**From:**  
**To:** [DCAdmin](#)  
**Subject:** Application Number 2023/91304  
**Date:** 08 June 2023 21:29:27  
**Importance:** High

We refer to the above planning application and would like to comment as follows:

| rev   | description                  | drawn                    | auth                       | date                     |
|---|------------------------------|--------------------------|----------------------------|--------------------------|
| Project No<br><b>2835</b>   | Drawing No<br><b>(100)02</b> | Rev                      |                            |                          |

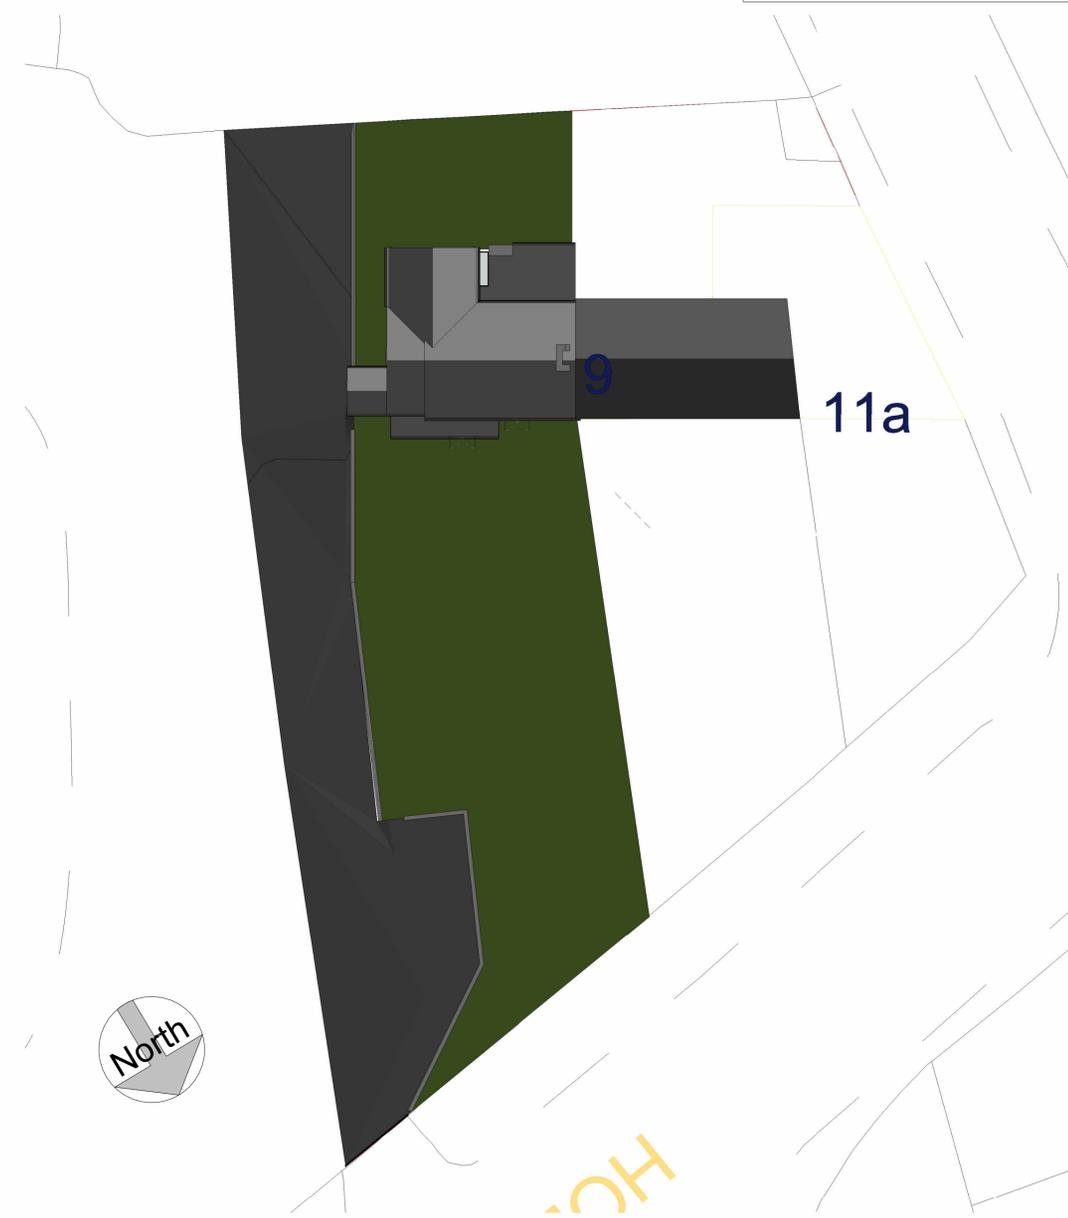
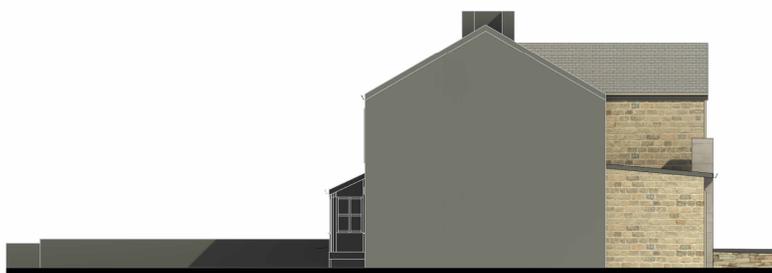
1. We have been informed that part of the proposed extension would be built on land belonging to number 11 Holmfirth Road.
2. If the owner of no. 9 was able to purchase all of the additional land, the large extension would overshadow the 2 other neighbouring properties
3. The very pleasant rear view of the small wooded area would be diminished considerably. This would have a negative impact on both neighbouring properties.
4. The contemporary style of the proposed addition, albeit very smart, is not in keeping with the remainder of the terrace.
